# CITY OF ALBUQUERQUE

June 24, 2016

**Re: Del Webb Amenity Center  
9100 Del Webb Lane  
Request for 30 Day Temporary C.O.-Accepted  
Engineer's Stamp dated: 2-19-15 (H09D017C1)  
Certification dated: 6-22-16**

GRADING PLAN

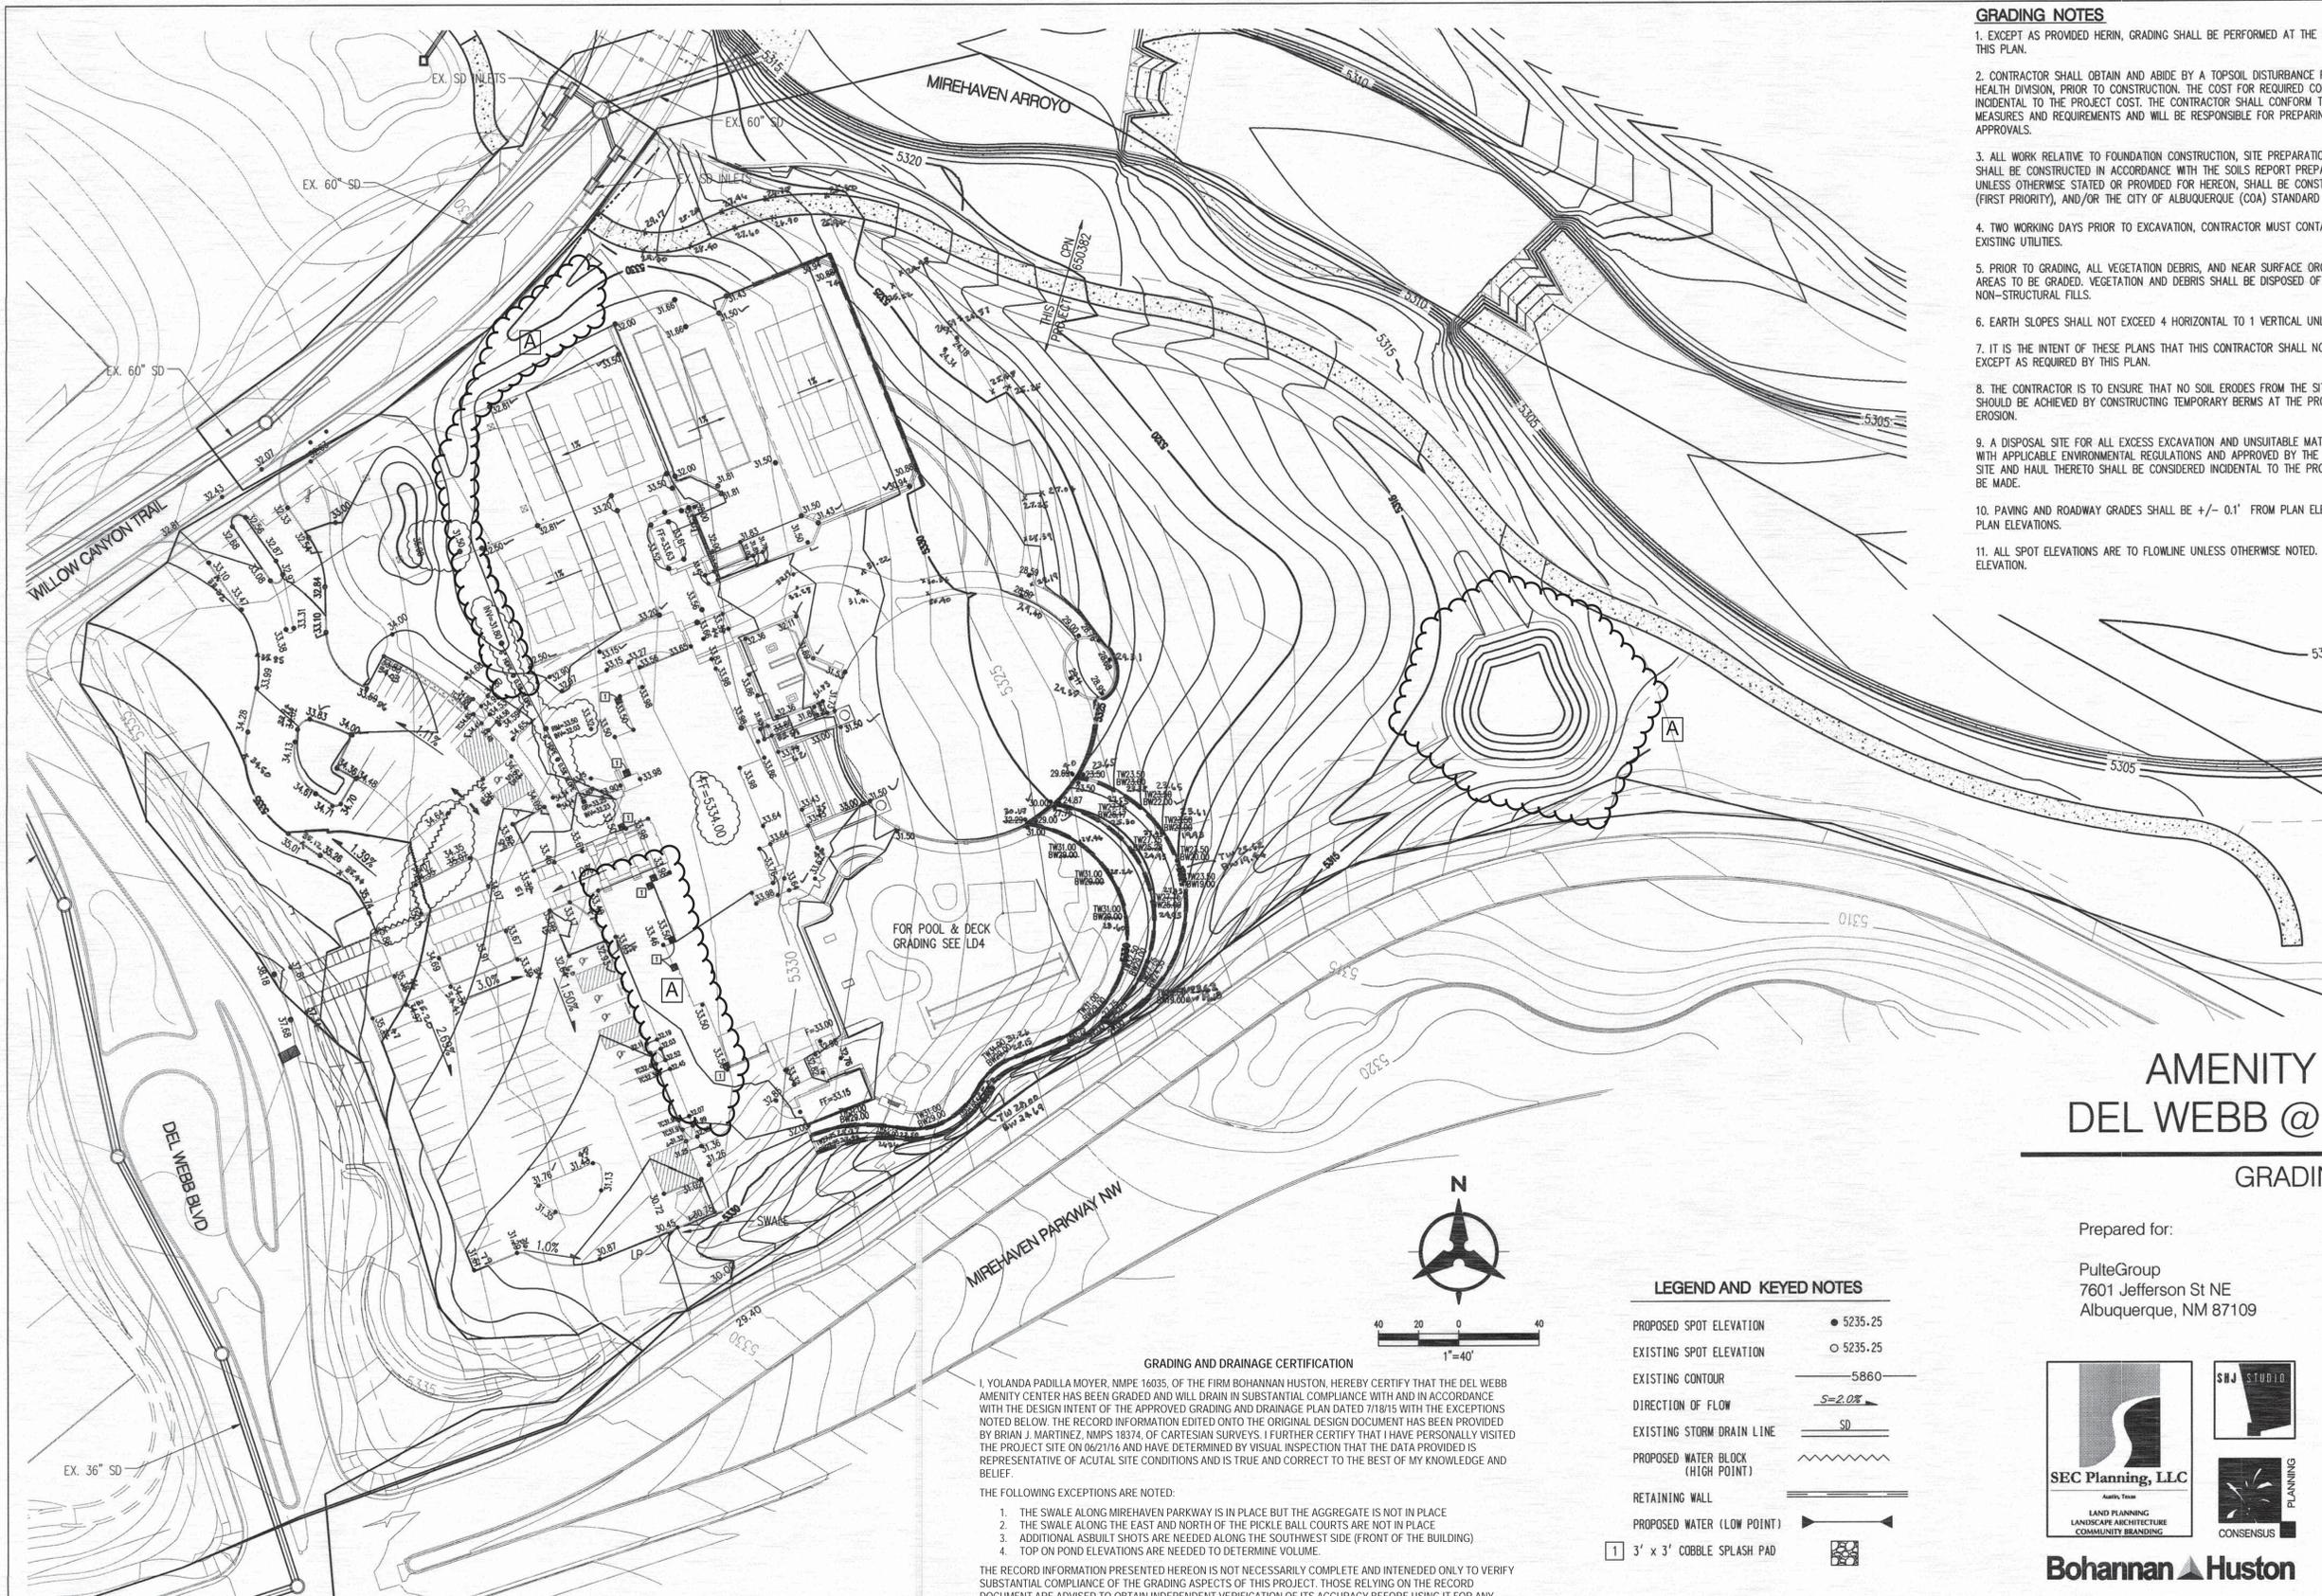
- The swale along Mirehaven Parkway is in place but the aggregate is not in place.
- The swale along the East and North of the pickle ball courts are not in place.
- Additional as-built shots are needed along the SW side (front of the building).
- Top of pond elevations are needed to determine volume.
- Prior to final CO, the missing grate near the front entrance (to drain under the sidewalk) will need to be installed.
- It is recommended (not required for CO) that the minor bird baths be addressed.
